DELEGATED HOUSEHOLDER DECISION

Item No.	Report of the Head of Planning, Transportation and Regeneration	
Address	10 FRAYS AVENUE WEST DRAYTON	
Development:	Single storey rear extension, single storey side extension and raising of roof to allow conversion of roofspace to habitable use to include 1 side, 1 rear and 1 front dormer and 1 side rooflight	
LBH Ref Nos:	5235/APP/2021/1541	
Drawing Nos:	N/619/01 N/619/02 N/619/03 Location Plan (1:1250) Flood Risk Assessment	
Date Plans Received:	19/04/2021	Date(s) of Amendment(s):
Date Application Valid:	22/04/2021

- 1.3. The proposed floor plans and elevations are shown for reference below:

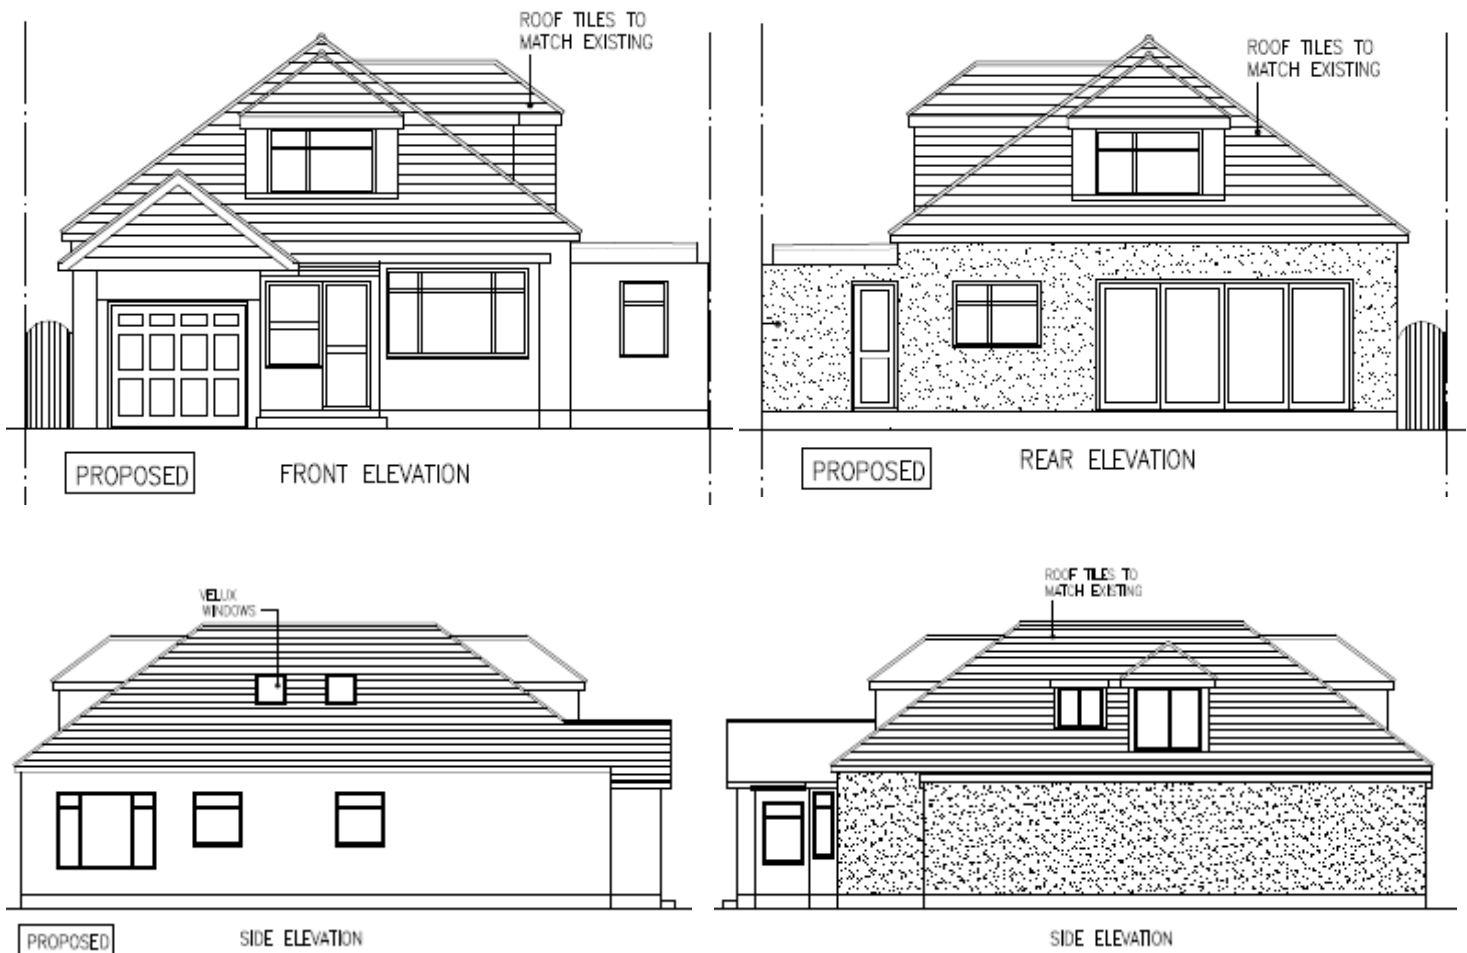
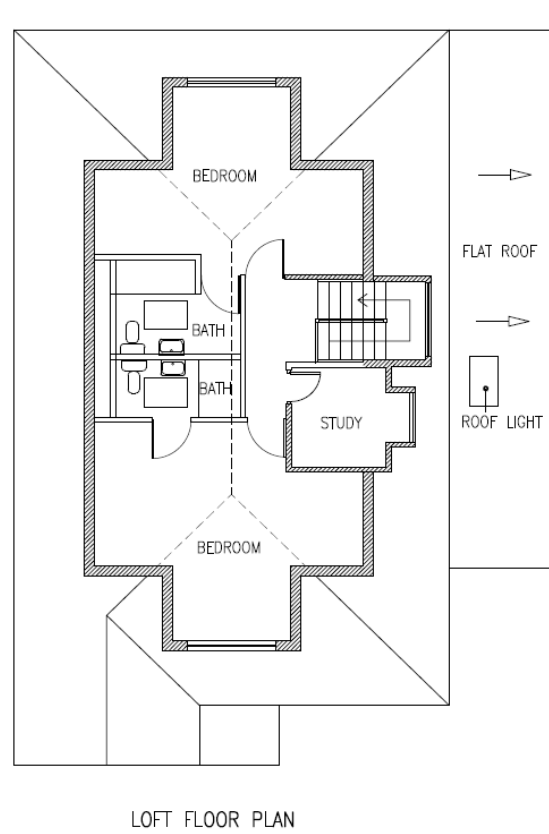
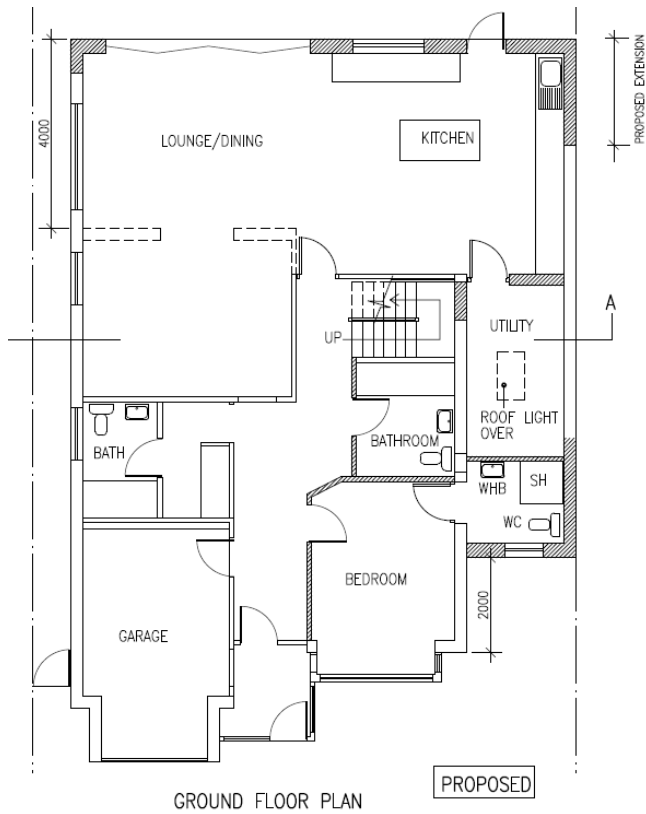
The proposed development would see the roof of the property replaced and raised by approximately 30cm. Existing front and rear dormers would be replaced with larger dormers. 2 side elevation dormers and rooflights would also be added to the roof and the property would be extended to the rear at ground and roof level. A single storey side extension is also proposed.

Raising the height of the existing building would disrupt the proportions of the property creating an uncomfortable gap between the top of the windows and eaves line. Due to their excessive size and siting the proposed dormers would fail to form subordinate additions to the property. Due to the amount of dormers proposed and their size, the resulting roof the property is likely to appear cluttered and top heavy, detracting from its simple, balanced, original architectural composition. It is therefore considered that the proposed dormers and roof height raising would cause significant harm to the character and appearance of the original property.

At present the property sits in between pitched roof bungalows of similar height. Raising the ridge of the property would disrupt the relatively uniform height that exists between the 3 bungalows. The larger of the two proposed side dormers would diminish the hipped roof form of the property, making the host property appear out of character with neighbouring bungalows. Collectively the increase in ridge height and oversized dormers would make the resulting building appear overly prominent within the street scene and amongst the neighbouring bungalows. For the reasons mentioned above it is considered that the proposed development would cause harm to the collective appearance of the bungalows, street scene and ASLC.

The proposed single storey side extension would be approximately 3m high and its flank wall would be sited within 70cm of the ground floor bedroom window of No.8 Frays Avenue. The side elevation window is the sole source of light and outlook for the room. Due to its height and close proximity to the window the side extension is likely to lead to a significant loss of light and outlook to the bedroom, causing significant harm to the amenities of No.8. The proposed development is therefore considered to be contrary to Policies DMHD 1 and DMHB 11 of the Hillingdon Local Plan: Part Two - Development Management Policies (2020).
